Matthew Riley - EPQ comments - Exhibition - Tarrawonga and Rocglen Coal Mine Modifications (11_0047 MOD 1 & 10_0015 MOD 1) (Narrabri & Gunnedah LGA's)

The EPA raises the following comments in relation to the Tarrawonga and Rocglen Coal Mine Modifications (11_0047 MOD 1 & 10_0015 MOD 1).

| Figure 2 | Land Ownership |

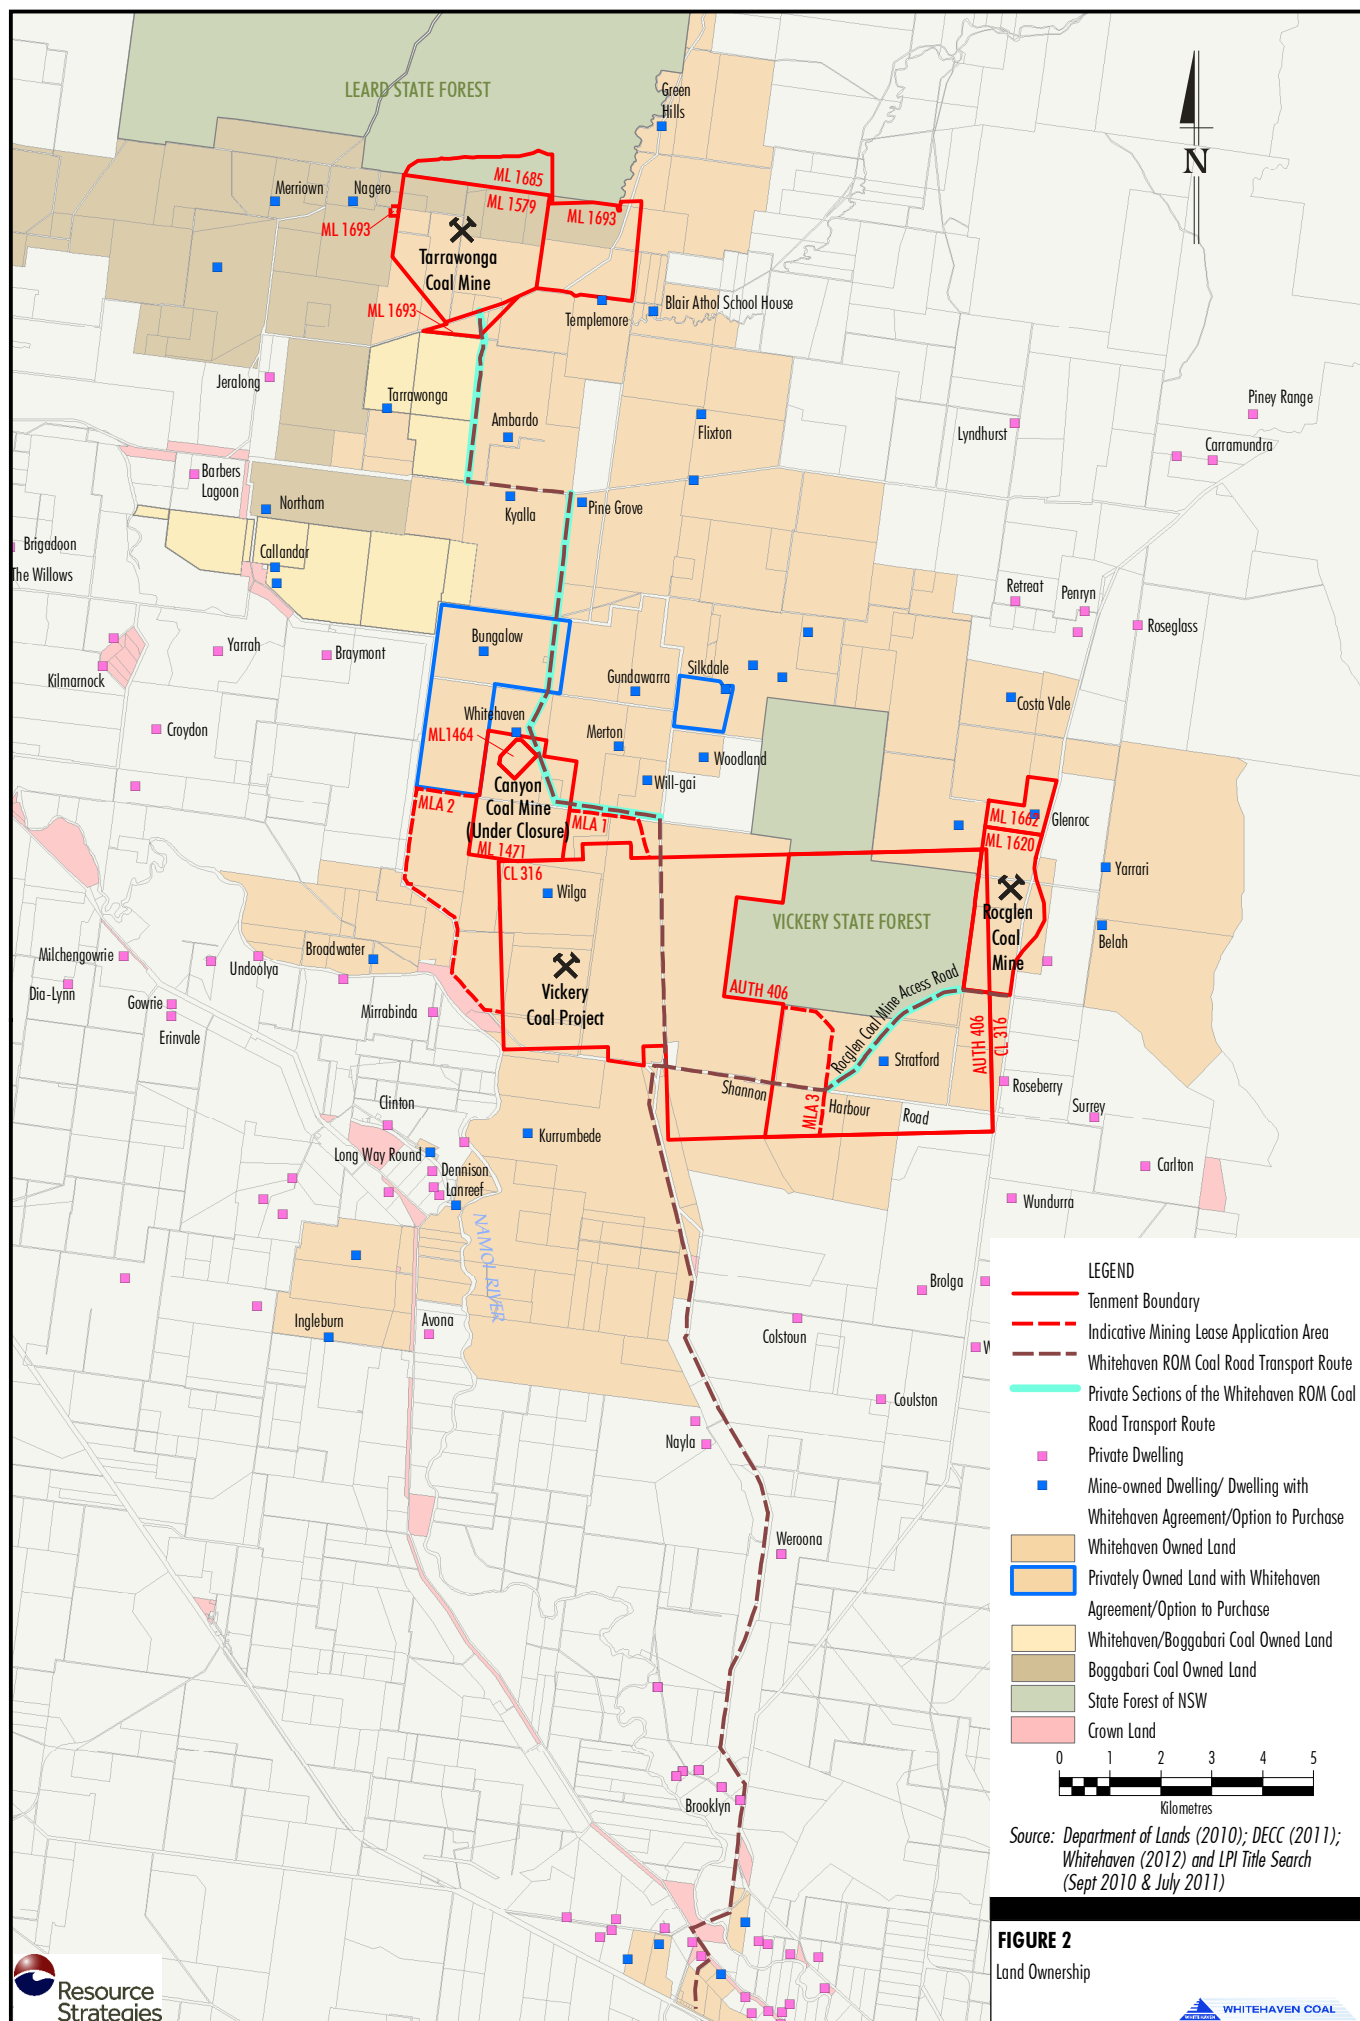
Modification- Tarrawonga Coal Mine (p1) states *"All dwellings proximal to the northern section of the Approved Road Transport Route are currently owned by Whitehaven and/ or BCPL, or are subject to a purchase agreement by Whitehaven (Figure 2)".*

Any dwelling which is owned by BCPL should really have a private agreement with Tarrawonga (and I suggest vice versa) so there is a legal mechanism in which impacts associated with each other's activities are addressed appropriately. To simply indicate, that because the residence is owned by another mine, impacts do not need to be considered does not appear to be appropriate.
